From: [NectonSubstationAction Messenger](#)
To: [Norfolk Boreas](#)
Subject: Response to applicant's answer Table 1
Date: 14 December 2019 09:51:04

Comments on Relevant Representations Norfolk Boreas Offshore Wind Farm ExA.RR.D0.V1
November 2019 Page 7

Table 1 Applicant responses to Relevant Representations in relation to Site Selection
No. Topic/ Issue Relevant Representation Number

SCENARIO 1
Figure: 29.28b (1 of 2)
Viewpoint 6: A47 Top Farm

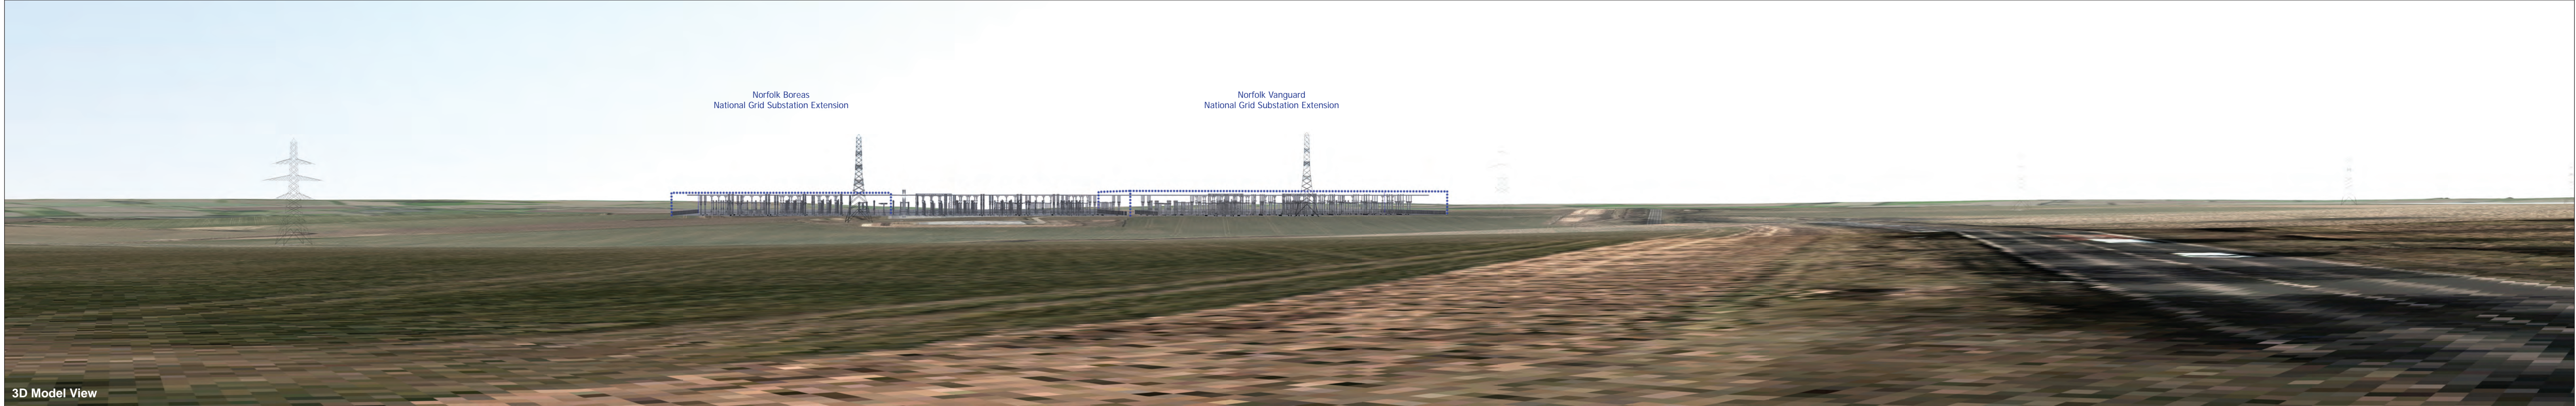
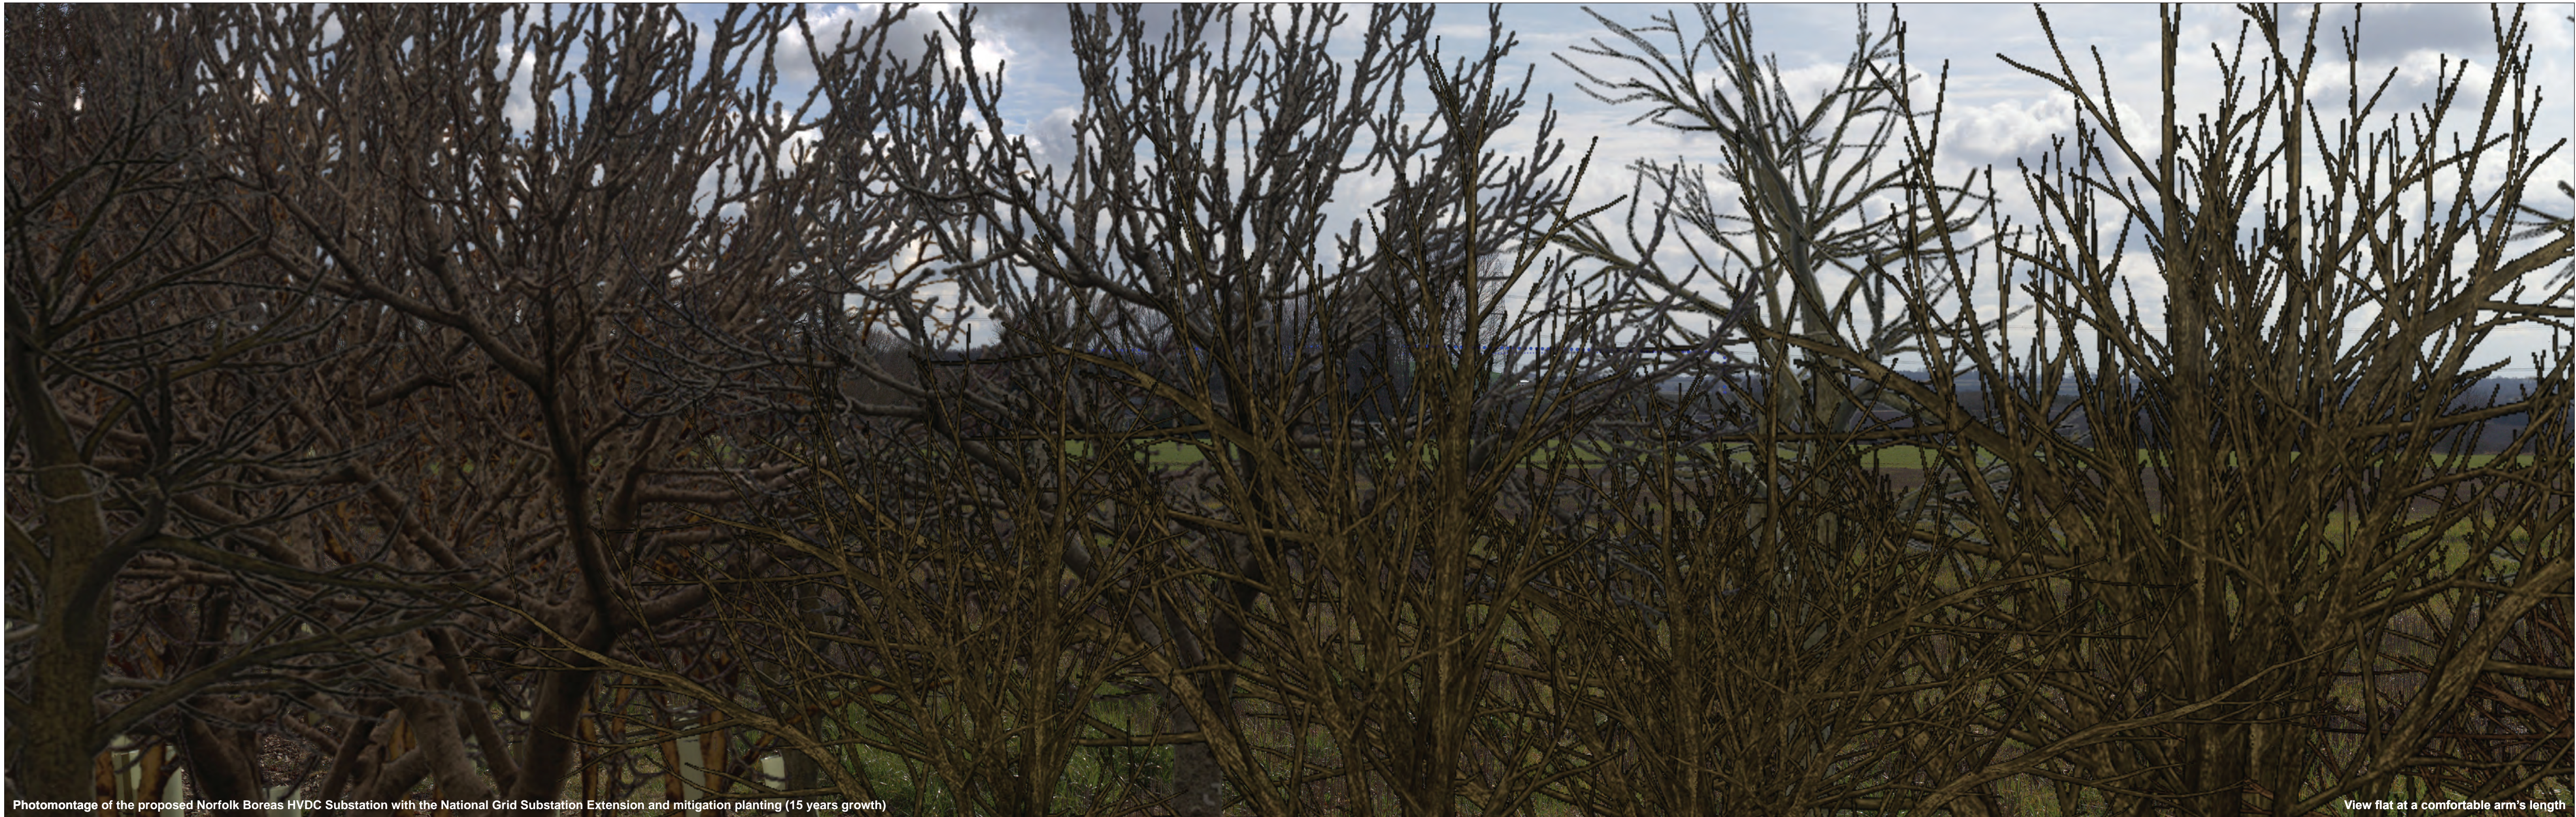
The applicant has sought to justify their site selection in many answers, however they have still failed to satisfactorily answer the question as to why they refused to seriously consider Top Farm, which is situated very close to their current site but on lower ground. The only reason they have given is that it would require more work as it would need to be levelled. Surely anyone with common sense would see this as a wonderful opportunity, especially as the purchase would not require a CPO? The opportunity is to use the soil taken off to create bunds, which would then be planted on. As the lowest point of Top Farm is where the access road comes off the A47 it would save money in cabling. The lowest point which we stood on with the Vanguard PI team, is some 10m below the chosen site. With earth bunds this could be increased by perhaps 5 metres to 15m. Suitable planting would then be affective as soon as it reached 4m.

"The grid connection point decision undertaken with National Grid considered a range of alternative connection points. This included, for example, a new connection point to National Grid closer to the coast. However, to accommodate such a connection, National Grid would have to connect to an existing substation via overhead lines, due to the length of the 400kV AC connection that would be required. The decision was therefore taken to avoid overhead lines in order to minimise visual impacts and instead install underground cables to an existing National Grid substation with the required capacity."
